**MODIFICATION REQUEST:
CASUARINA TOWN CENTRE
TWEED COAST ROAD, CASUARINA
06_0258 MOD 7**

Secretary's Environmental Assessment Report
Section 75W of the
Environmental Planning and Assessment Act 1979

June 2014

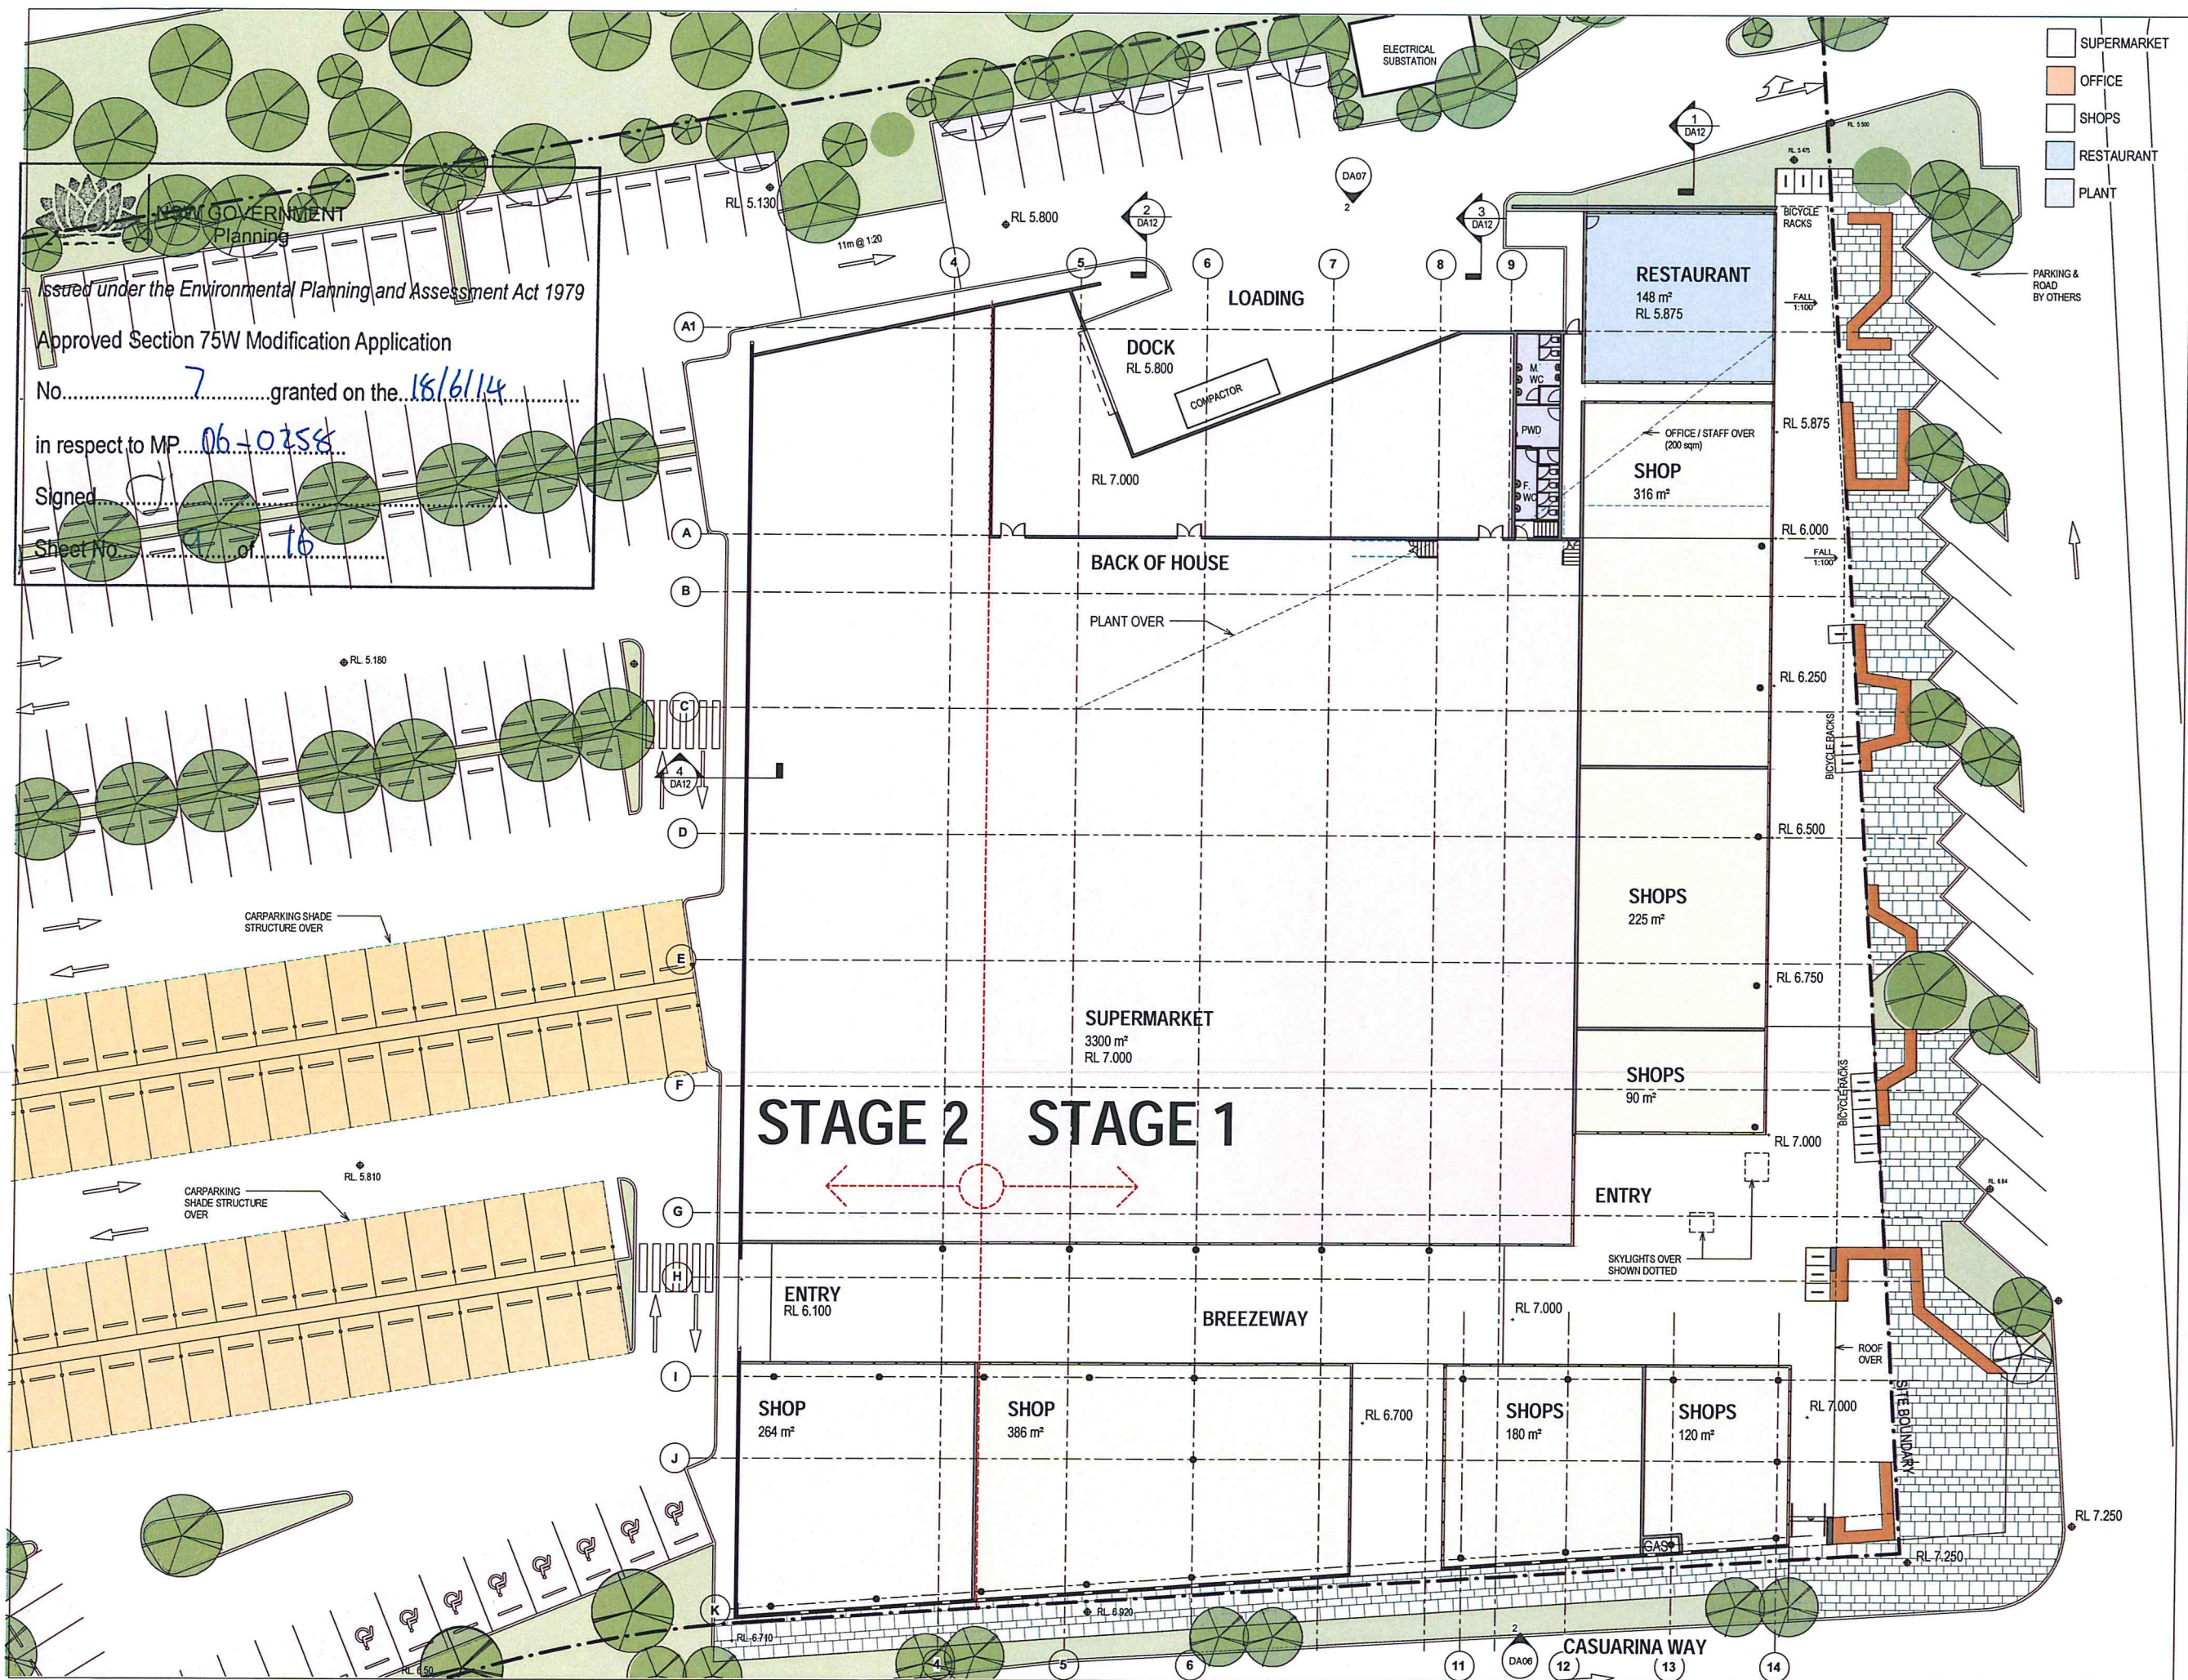
- vehicular parking provisions for the site should be considered as part of the department's assessment;
- the disabled car parks on the car parking plan do not comply with the Australian Standards (AS 2890.6 – off street parking for people with a disability); and
- it is recommended that a wider road width be considered within the car parking area given it will become a high turnover area.

A total of 16 disabled car parking spaces are proposed for Stage 1 of the retail centre, which will be reduced to eight spaces as part of the Stage 2 expansion. Council did not raise concern in regards to the proposed number of disabled car parking spaces. However, it was advised that the width of the proposed disabled car parking spaces do not comply with Australian Standards AS2890.6 – *Off street parking for people with disabilities* (AS2890.6). AS2890.6 requires a 2.4m wide parking bay plus an adjacent clear space of 2.4m in width (this space can be shared between two disabled car parking bays).

The proponent advised that the disabled car parking spaces have been designed with a width of 2.7m and that there is sufficient space to adjust the car parking arrangement to comply with the relevant standards. Compliance with the relevant standards will be a matter of consideration for the Principal Certifying Authority (PCA) prior to issuing a construction certificate for the retail centre.

In regards to the width of disabled car parking spaces, DP&E is satisfied that sufficient space is allocated in the submitted plans and that the detailed design of these spaces can be dealt with at construction certificate stage, which requires approval of the PCA. In addition, DP&E notes that Condition B19 – *Car Parking* requires disabled car parking to be provided in accordance with DCP A2. However, DCP A2 makes reference to a superseded version of AS2890.6 (AS2890.1 is currently referenced). Condition B19 is therefore recommended to be modified to delete the requirement for disabled car parking to be provided in accordance with DCP A2, to be replaced with AS2890.6. Council has indicated support for the recommended amendment.
